29 August 2018

APA Reference: 439221  
Your Reference: SSD8703

RE: **Proposed development of Springdale Solar Farm**  
**State Significant Development Application Number SSD8703**

PLANNING PERMIT APPLICATION

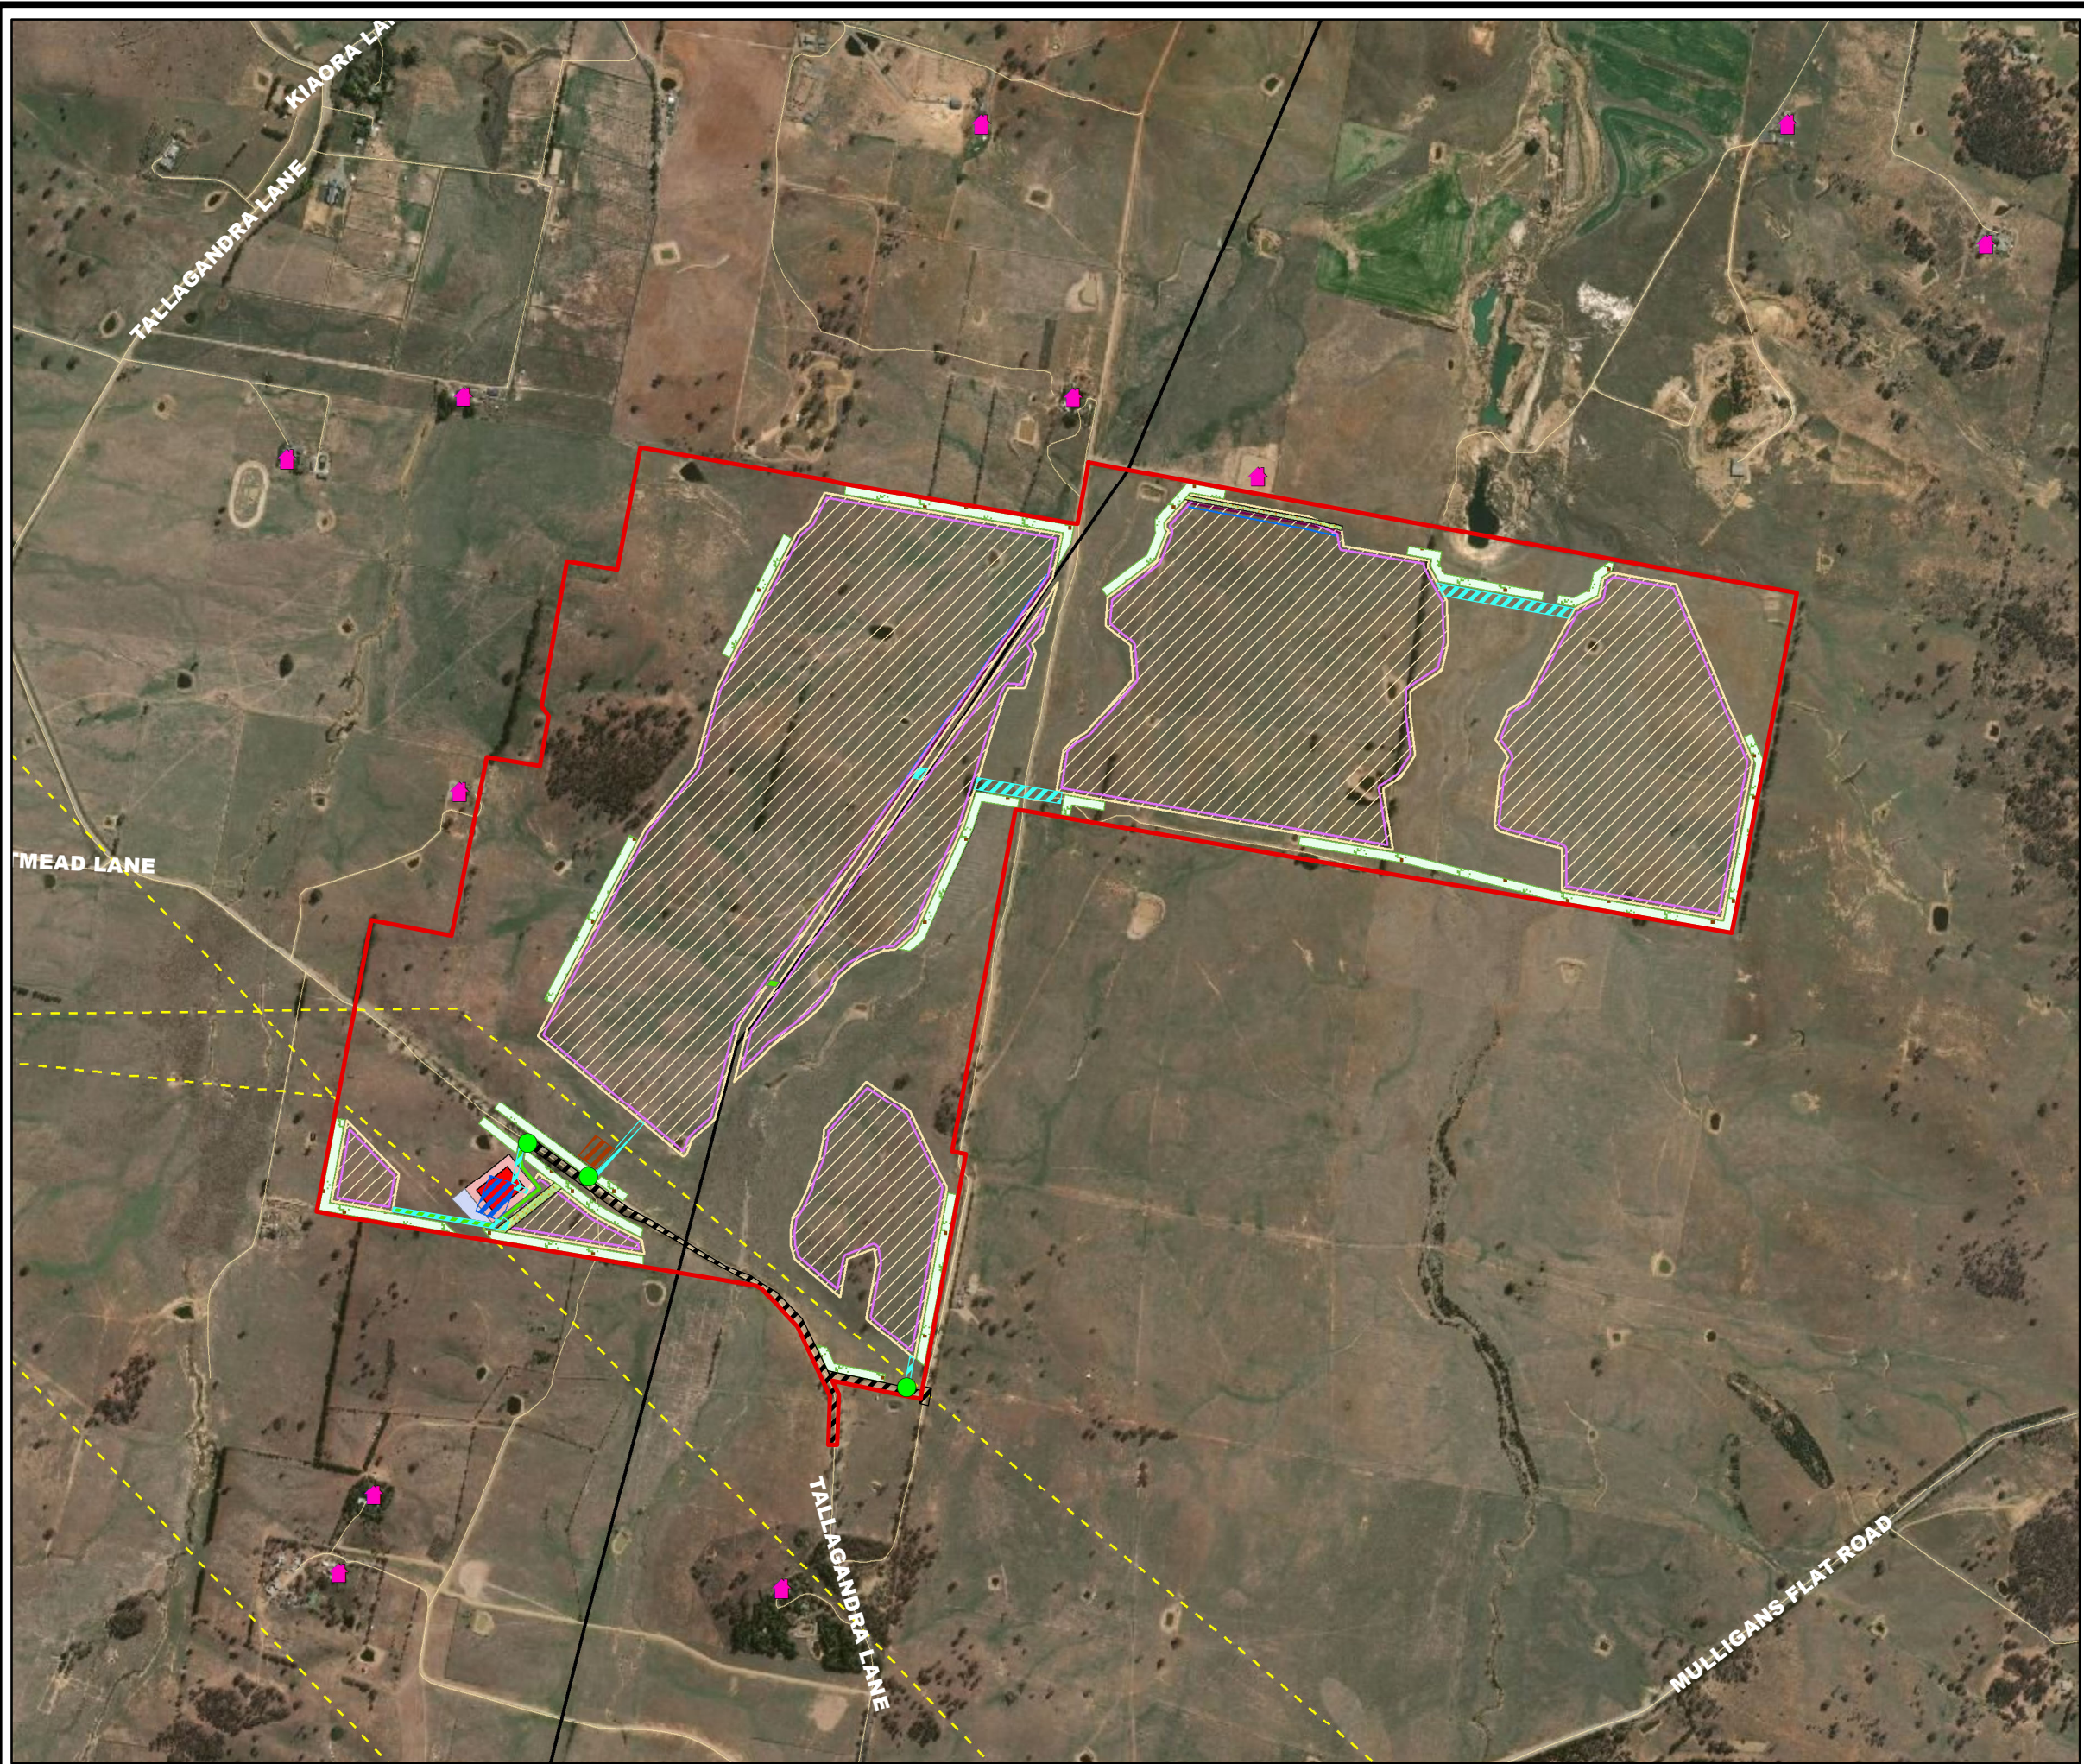
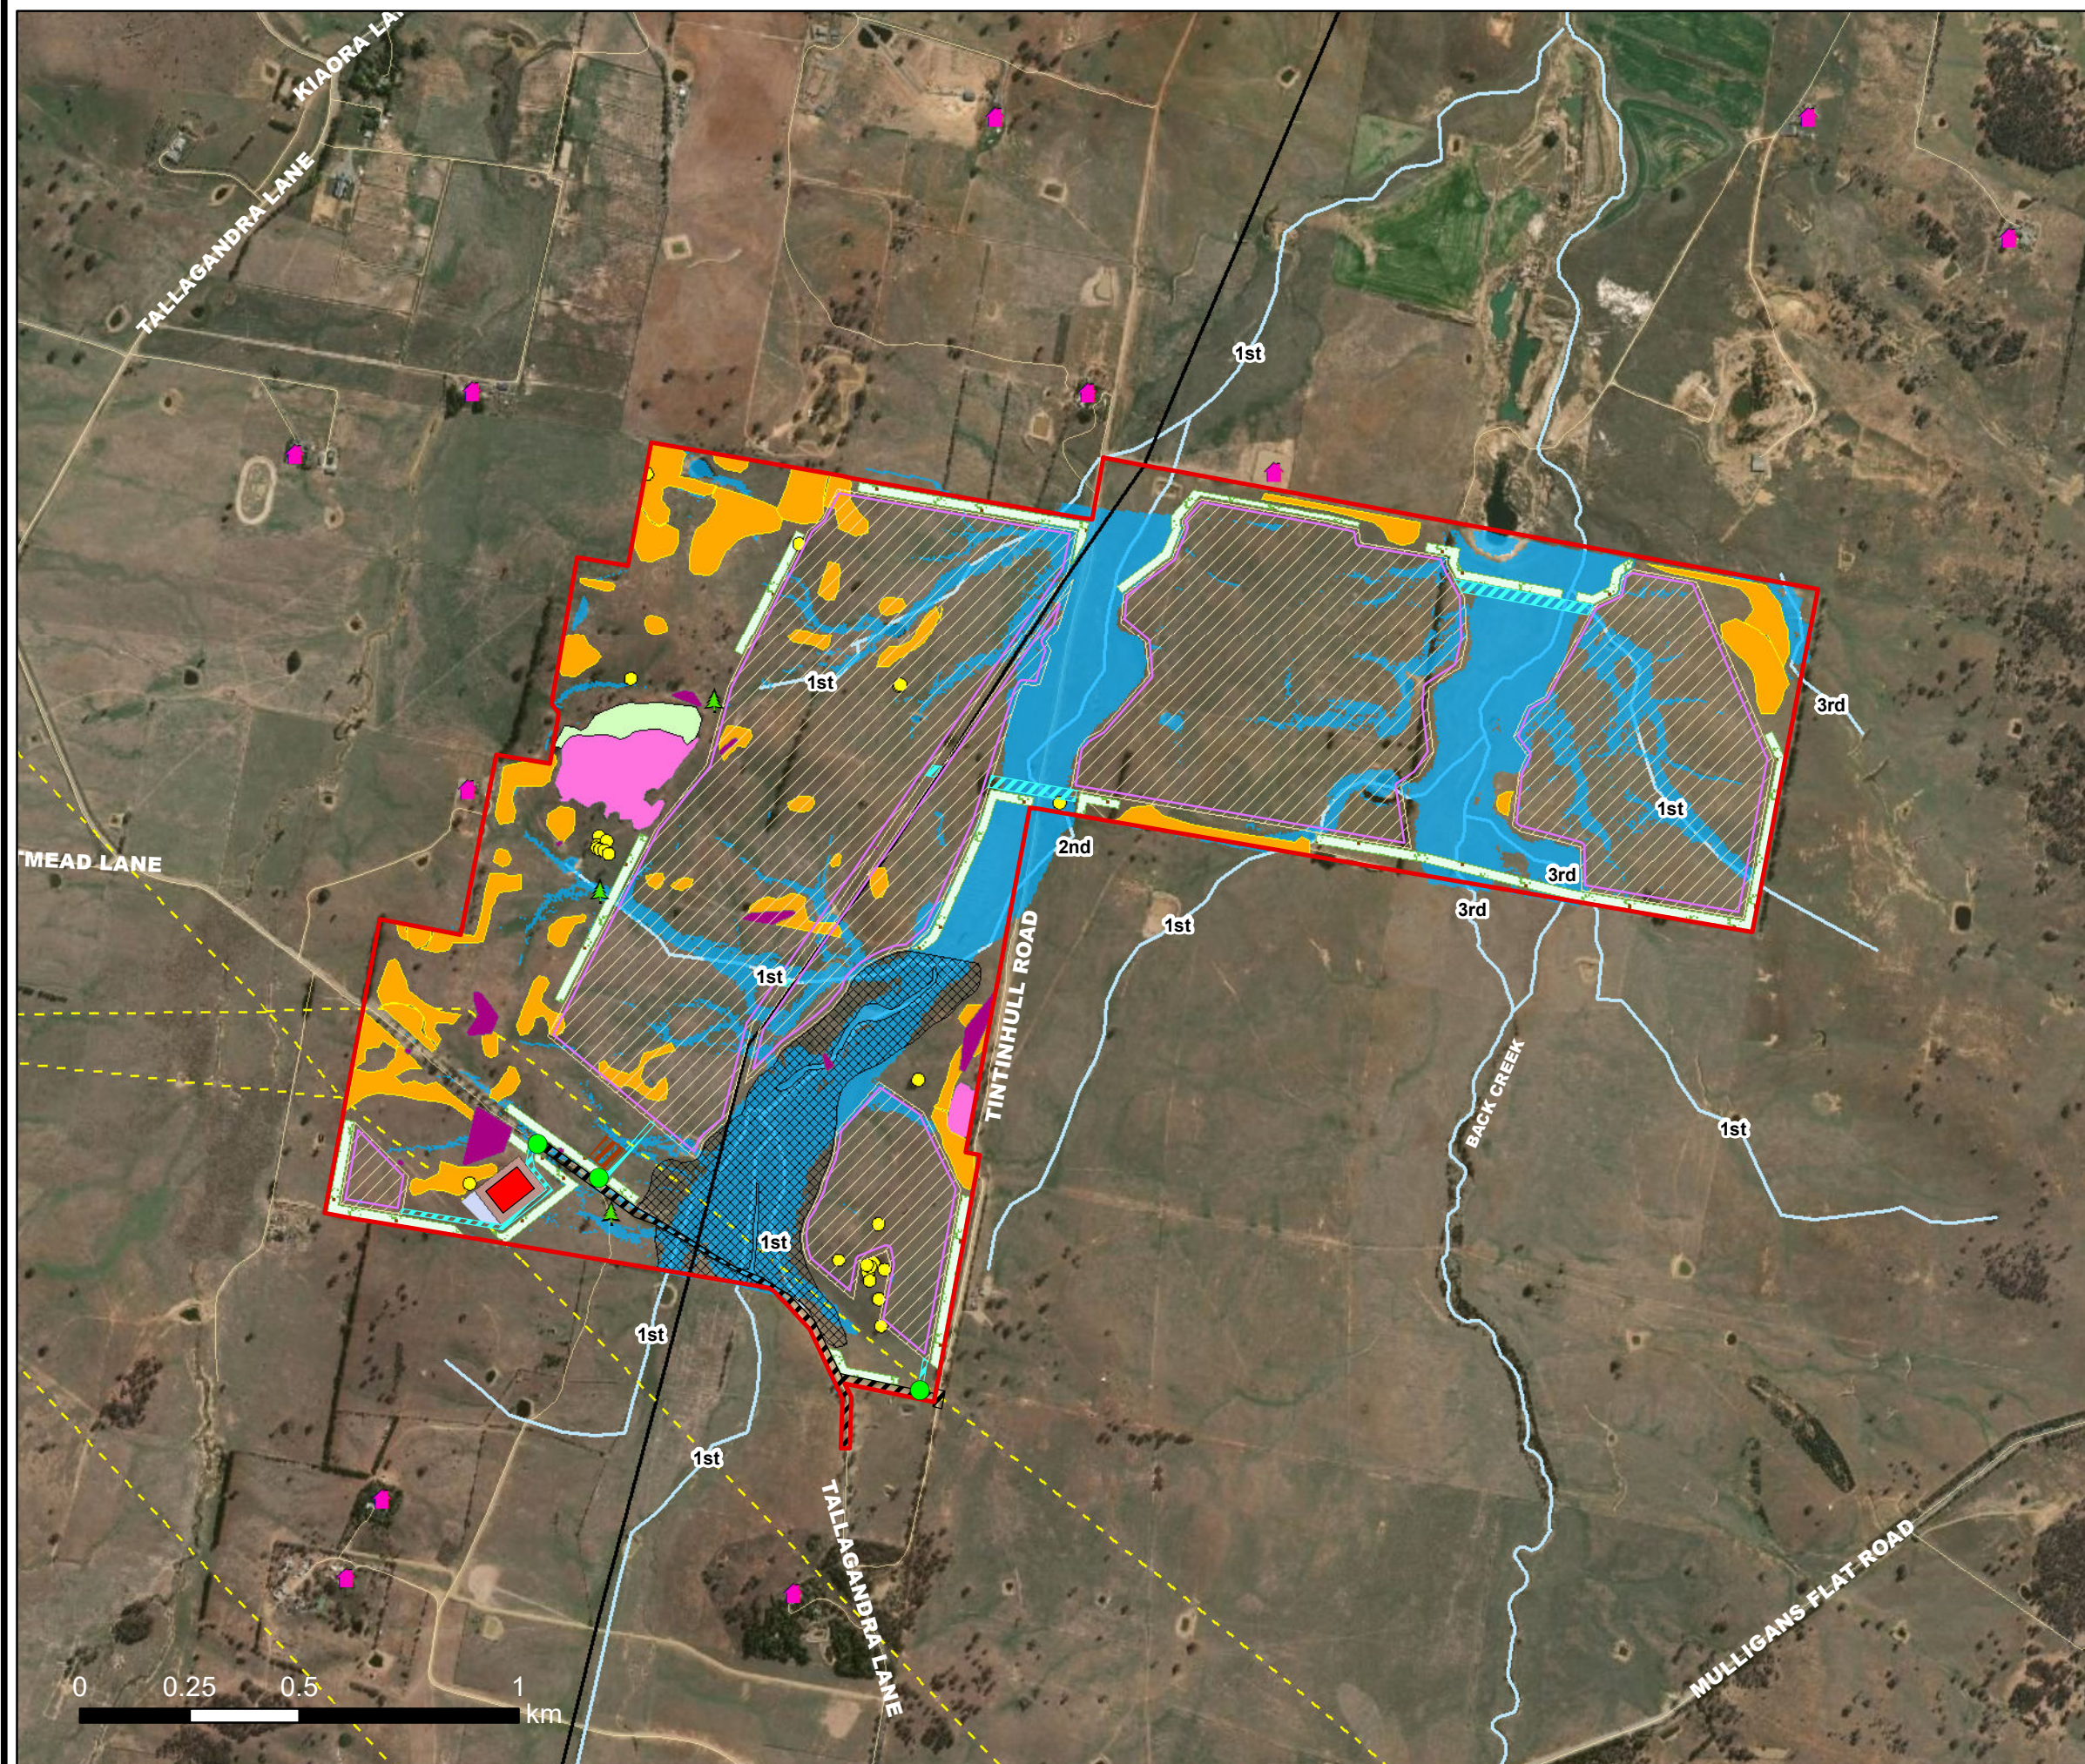
The proposal plan indicates a linear gap in the development footprint which appears to align with APA's pipeline and easement, however it is not accurately labelled as a 'high pressure gas transmission pipeline'. There is no statement or plan indicating the high pressure gas transmission pipeline (HPGTP) easement is clear of the siting of solar panels. The proposed development has significant areas of panels to both the east and west of the pipeline easement, and it appears these extend to the edge of the HPGTP easement. The proposed plan shows an internal road crossing of the pipeline in the northern part of the site.

A single area for both control building and substation is located to the south-west of the development site, west of APA's pipeline. Regardless of the final area for control building and substation, the need for crossings of the pipeline is anticipated. These are expected to include:

All plans which include the area of the gas pipeline easement must have the easement clearly identified with hatching on the full width of the easement. The easement must also be clearly labelled as *'high pressure gas pipeline easement – no works to occur without the prior authorisation of the pipeline operator'*.
